**RE: 915 Silver Ave. SW**  
**Grading and Drainage Plan**  
**Engineer's Stamp Date: 07/15/19**  
**Hydrology File: K14D118**

Based upon the information provided in your submittal received 07/15/2019, the Grading & Drainage Plan **is not** approved for Building Permit and Grading Permit. The following comments need to be addressed for approval of the above referenced project:

Grading and Drainage

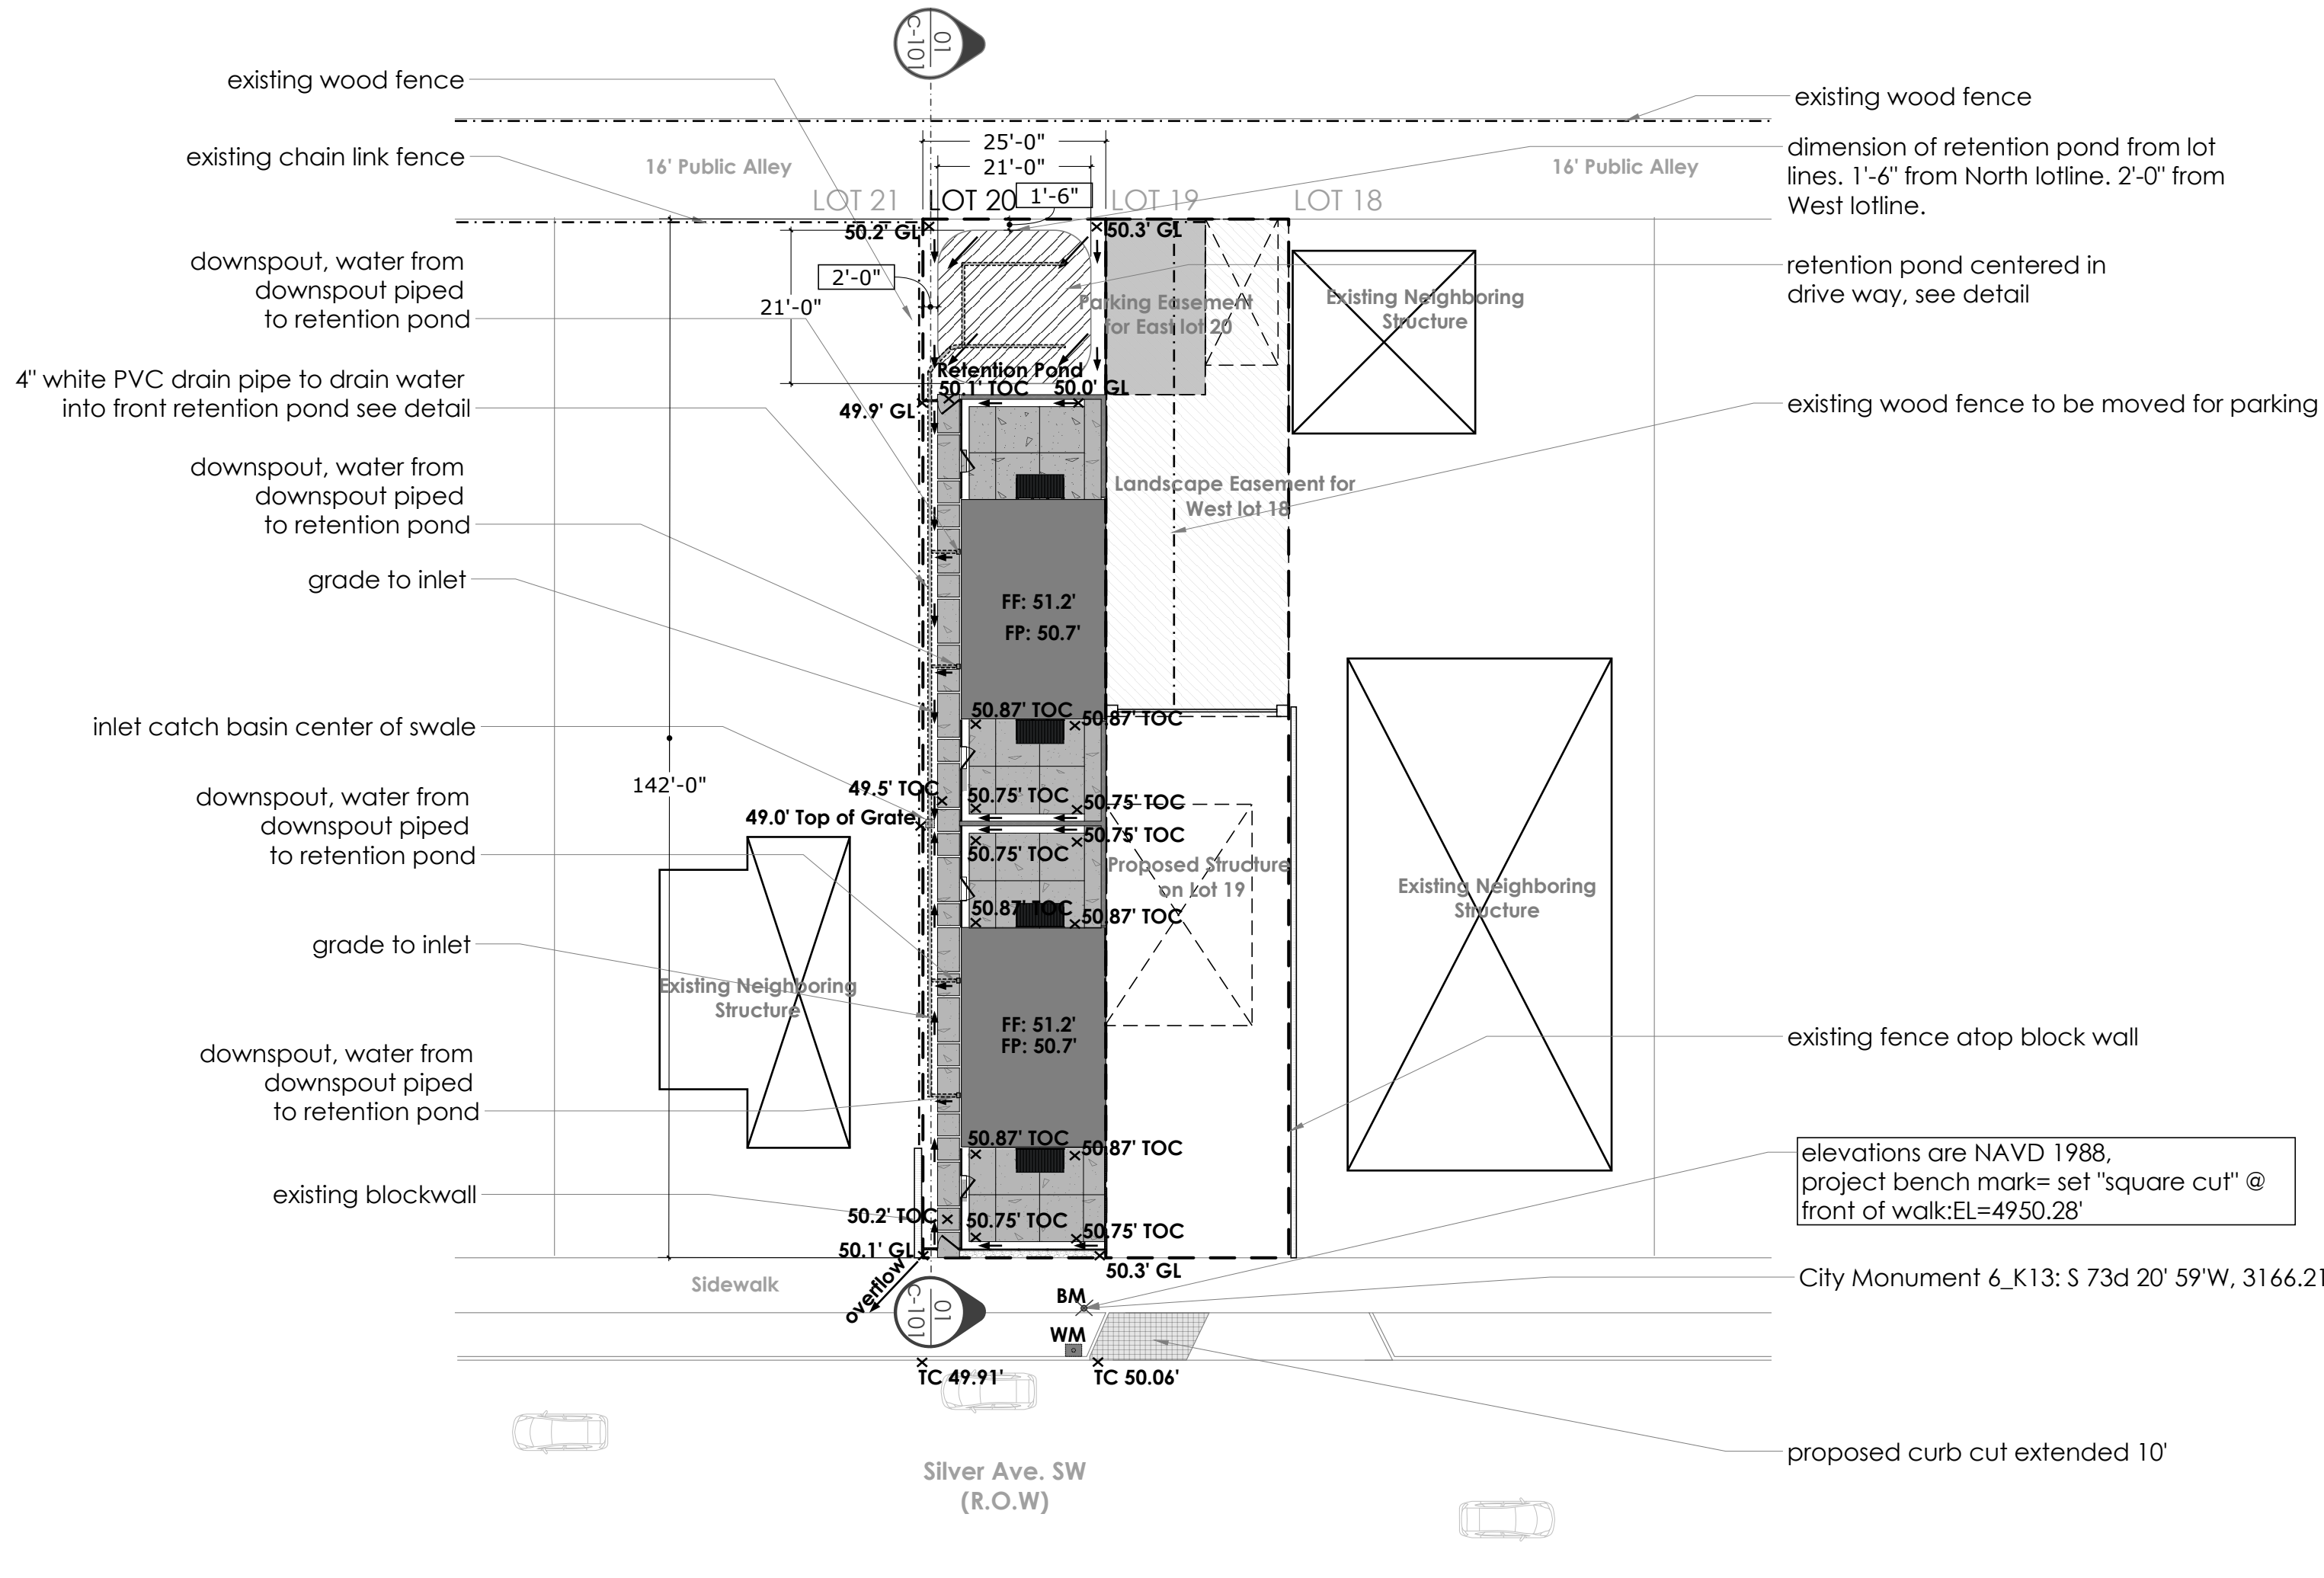
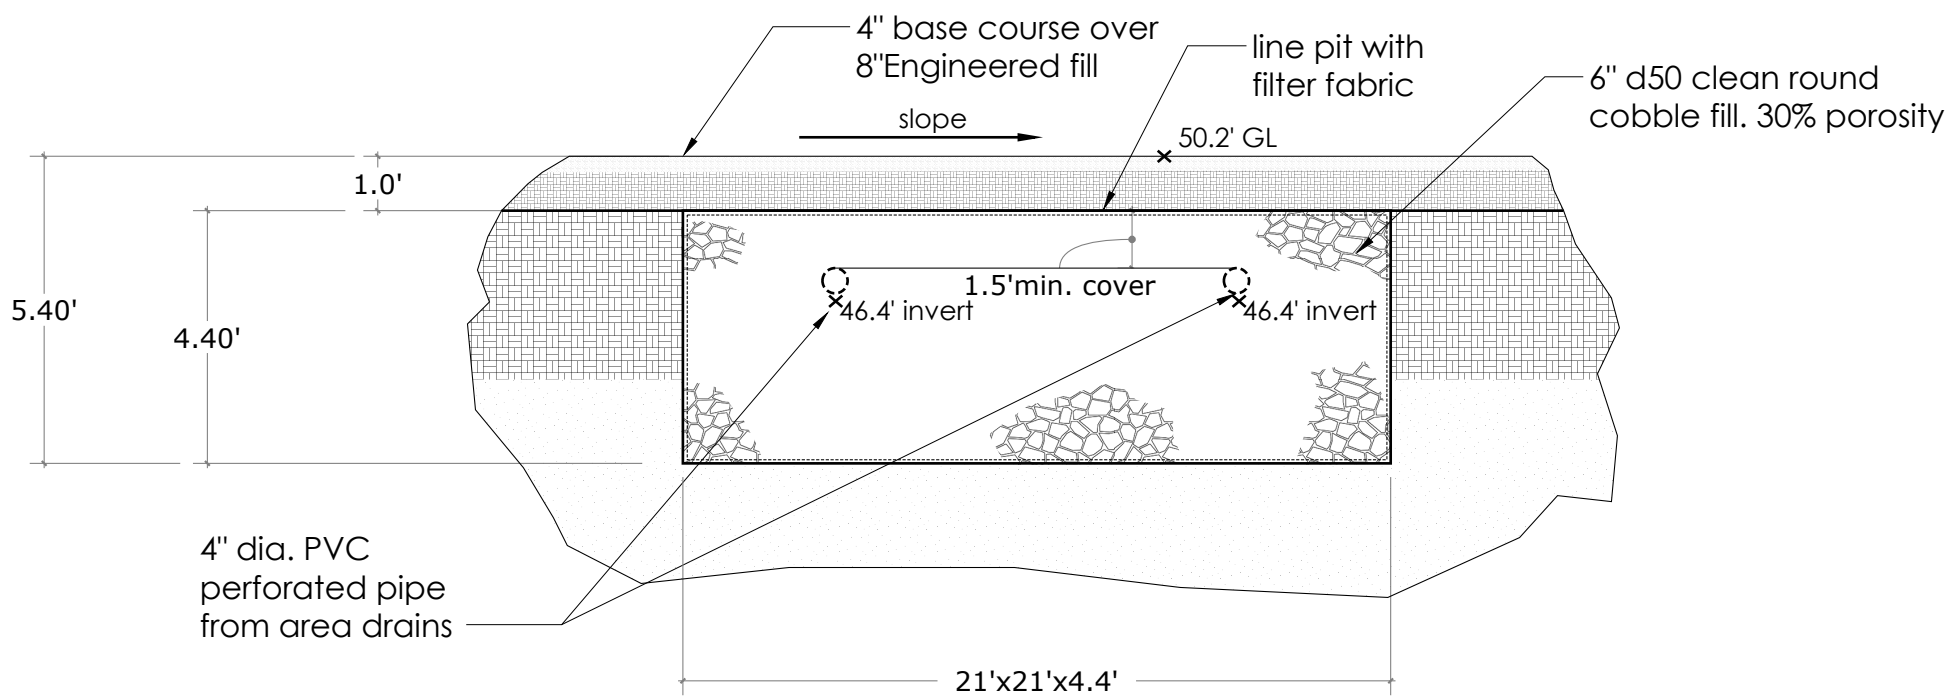
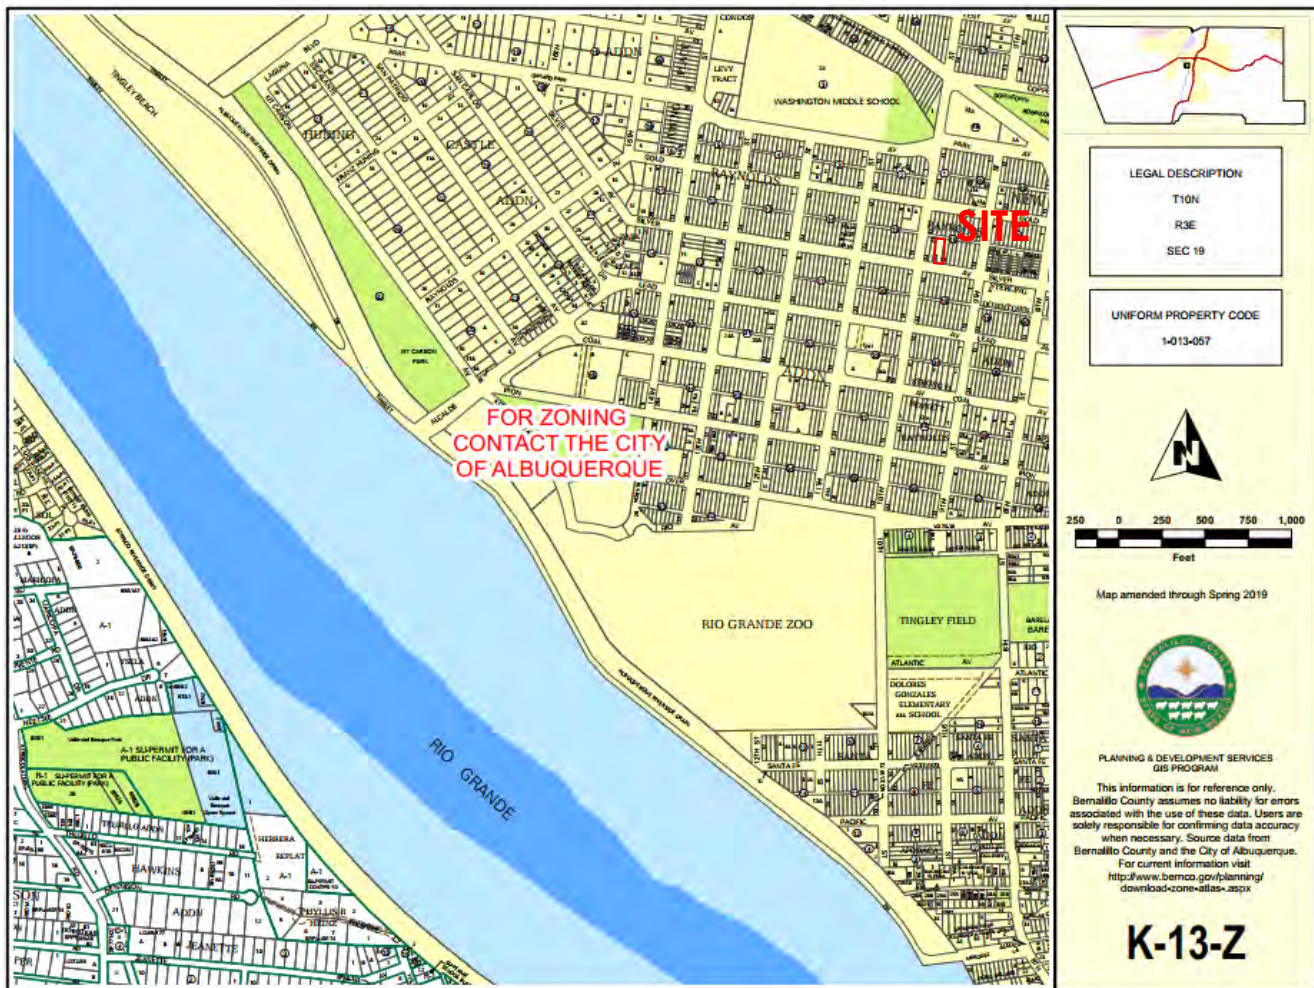
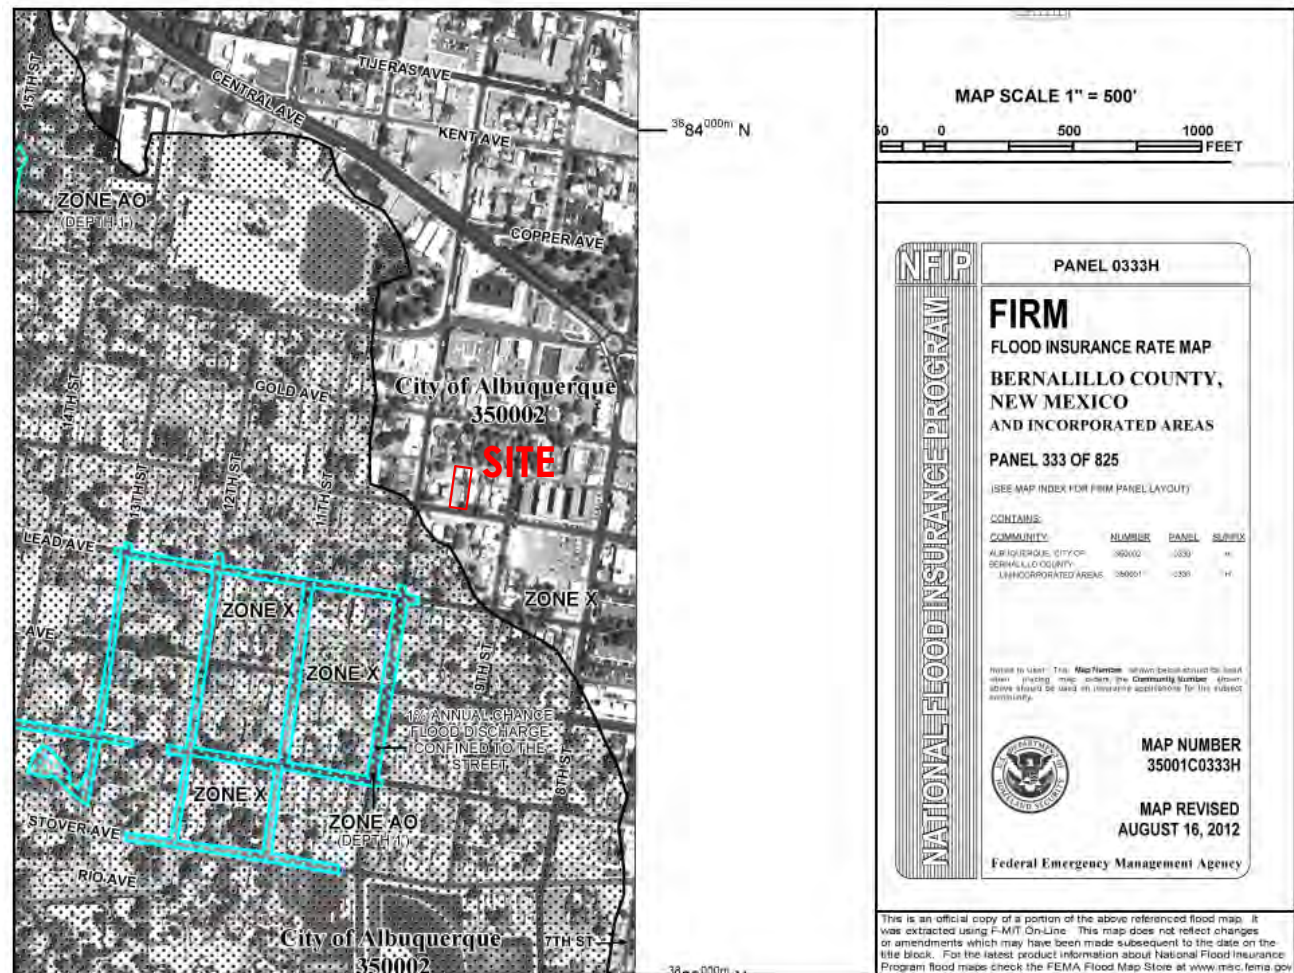
1. Even though the project benchmark is shown, please provide the City monument where this datum was taken.
2. Per the DPM Chapter 22 Section 7 - Grading Plan Checklist, please use 1" = 20' for the scale.
3. Per the DPM Chapter 22 Section 7 - Grading Plan Checklist, please provide a graphic scale.
4. Please show all existing structures, fences, sidewalk, and pavement on the lot, adjacent lots, Silver R.O.W., and alley. These items are important to tie proposed grading into and are any going to remain. See aerial.

5. Please label both the alley as a “16’ Public Alley” and Silver Ave SW R.O.W.
6. Please provide a legend showing all hatch patterns. I cannot tell what is being proposed.

7. Please provide all dimensions needed to build the proposed retention pond especially the dimension off the property line. Also please label the retention pond.

8. Please provide all dimensions needed to build the proposed French drain along the western property line especially the dimension off the property line.

9. Please provide size of the drain pipe and proposed inlet rim elevations along with pipe inverts.
10. Please provide the swale grades.
11. Since this site is in the Valley region, please follow Chapter 22 Section 5.G (Flat Grading Scheme). The following conditions must be applied to the site:

- Pad elevation shall be a minimum of one (1) foot above the highest adjacent proposed elevation.
  - The flow between the front yard and back yard cannot be obstructed. The stormwater must be allowed to equalize to the same level between the front yard and back yard.

- A permanent perimeter wall or barrier around the development is required to contain the 100 year 6 hour storm developed runoff.
  - The high point of the street should be four inches above the 100 year 6 hour storm water surface elevation.

12. Please show how the overflow of 0.1 cfs is leaving the site from the retention pond.

13. Please clarify the retention detail dimensions. Are these in inches or feet? Also please use aggregate instead of clean rounded cobble.
14. In the provided retention pond volume calculations, which dimensions are to be used in this project? There are five shown.

15. The site section does not provide any relevant information and can be removed.
16. As a reminder, if the project total area of disturbance (including the staging area and any work within the adjacent Right-of-Way) is 1 acre or more, then an Erosion and Sediment Control (ESC) Plan and Owner's certified Notice of Intent (NOI) is required to be submitted to the Stormwater Quality Engineer (Curtis Cherne, PE, [ccherne@cabq.gov](mailto:ccherne@cabq.gov), 924-3420) 14 days prior to any earth disturbance.
